DOCUMENT 2.3A

Project THE WEST MIDLANDS RAIL FREIGHT INTERCHANGE ORDER 201X	
Drawing Status SUBMISSION	
Drawing Title ACCESS AND RIGHTS OF WAY PLAN SHEET 1	
Regulation 5 (2) (k)	Document 2.3A
Drawn NW Date: JUNE 2018 Scale 1: 2500	Reviewed IF
Drawing No. WSP-70001979-SK-060	Rev. F

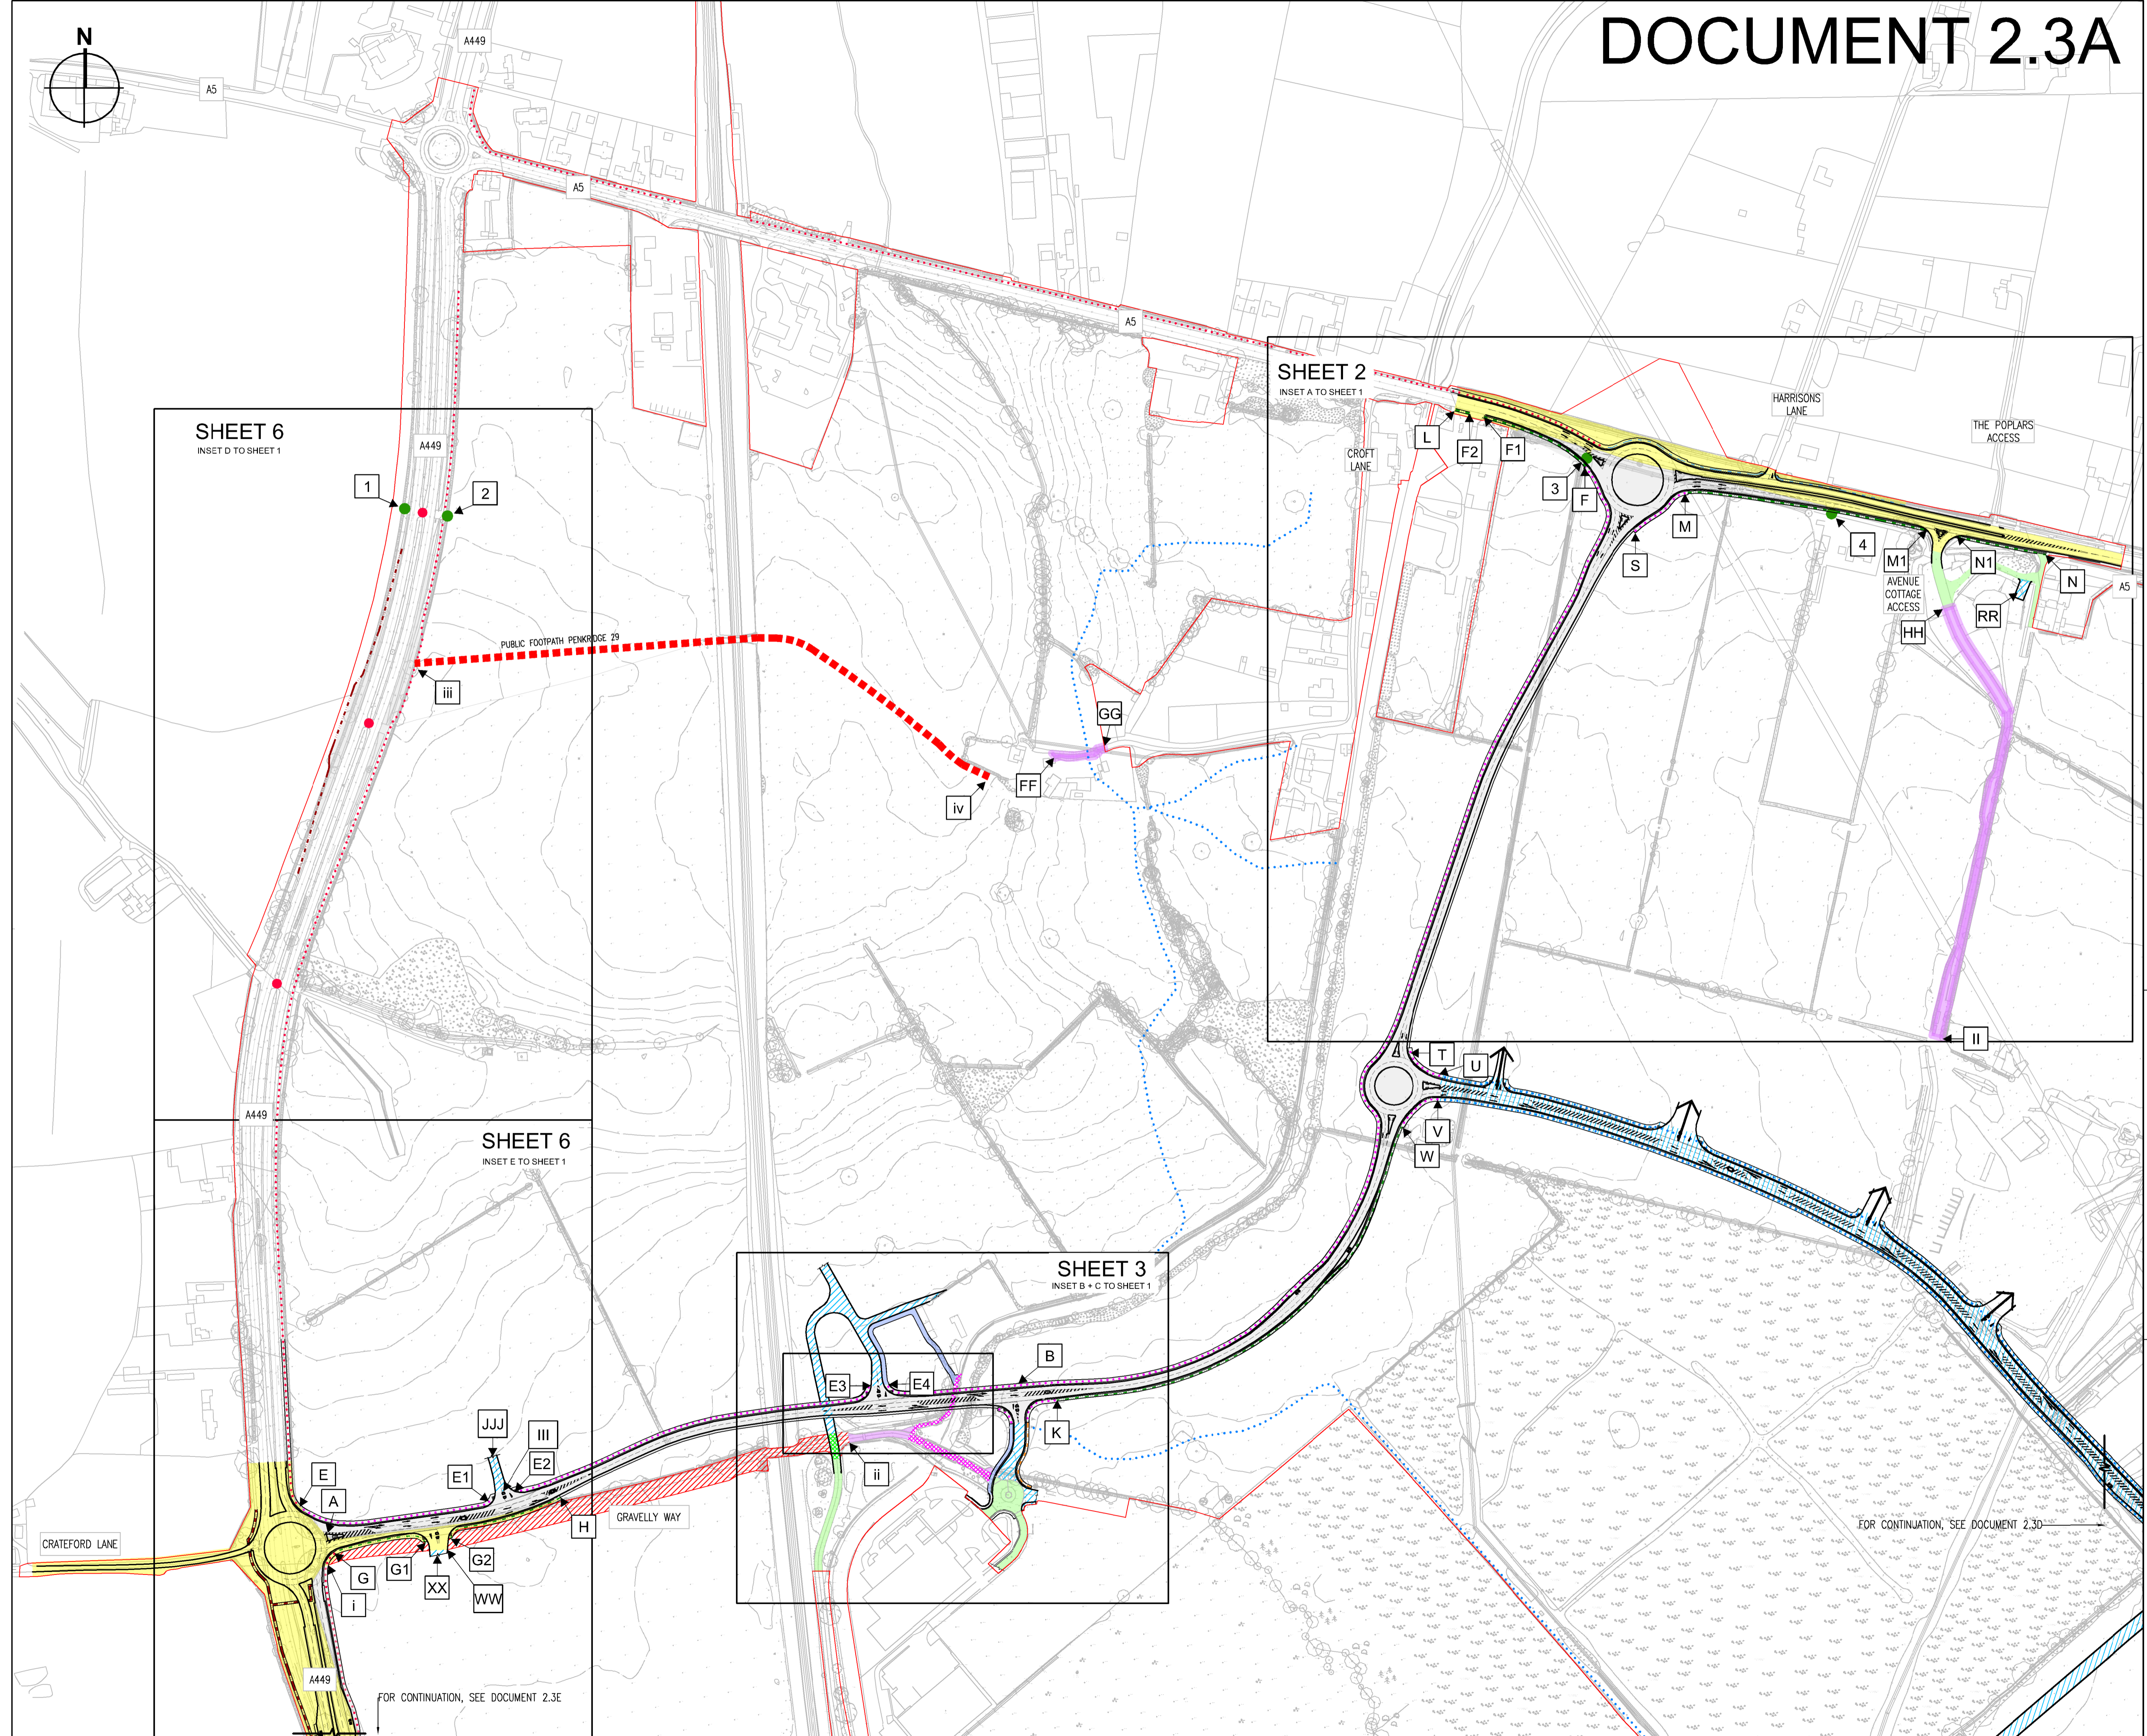
- CHANGES MADE TO DOCUMENT 2.3A SINCE DOO SUBMISSION:
- MAY 2019
- INSET F (SHEET 7) HAS BEEN CREATED TO SHOW THE CLOSURE OF THE BYWAY OPEN TO ALL TRAFFIC (BOAT) ON GRAVELLY WAY BUT THE DETAIL IS NOT SHOWN ON THIS SHEET 1 (PLEASE SEE DOCUMENT 2.3G).

- PEDESTRIAN CROSSING ON THE A449 SIGNALISED AND RELOCATED FURTHER SOUTH OF THE ROUNDABOUT IN RESPONSE TO COMMENTS FROM HIGHWAYS ENGLAND IN RSA.
 - PEDESTRIAN CROSSING ON GRAVELLY WAY MOVED EAST, STAGGERED AND SIGNALISED IN RESPONSE TO COMMENTS FROM HIGHWAYS ENGLAND IN RSA AND AS A RESULT, THE ACCESS TO THE RAIL TERMINAL HAS BEEN MOVED EAST. THE TOTAL WIDTH OF THE GRAVELLY WAY ARM HAS BEEN INCREASED TO PROVIDE SUFFICIENT WIDTH FOR THE CROSSING AND VEHICLE MOVEMENTS.

- FOOTWAY WEST OF THE A449 HAS BEEN RELOCATED AND RECLASSIFIED AS CYCLEWAY / FOOTWAY IN RESPONSE TO COMMENTS FROM HIGHWAYS ENGLAND IN THE RSA.
 - ADDITIONAL VERGE ON THE EASTERN SIDE OF THE A449 HAS BEEN ALLOCATED TO ENSURE VISIBILITY TO THE PEDESTRIAN CROSSINGS IS PROTECTED.
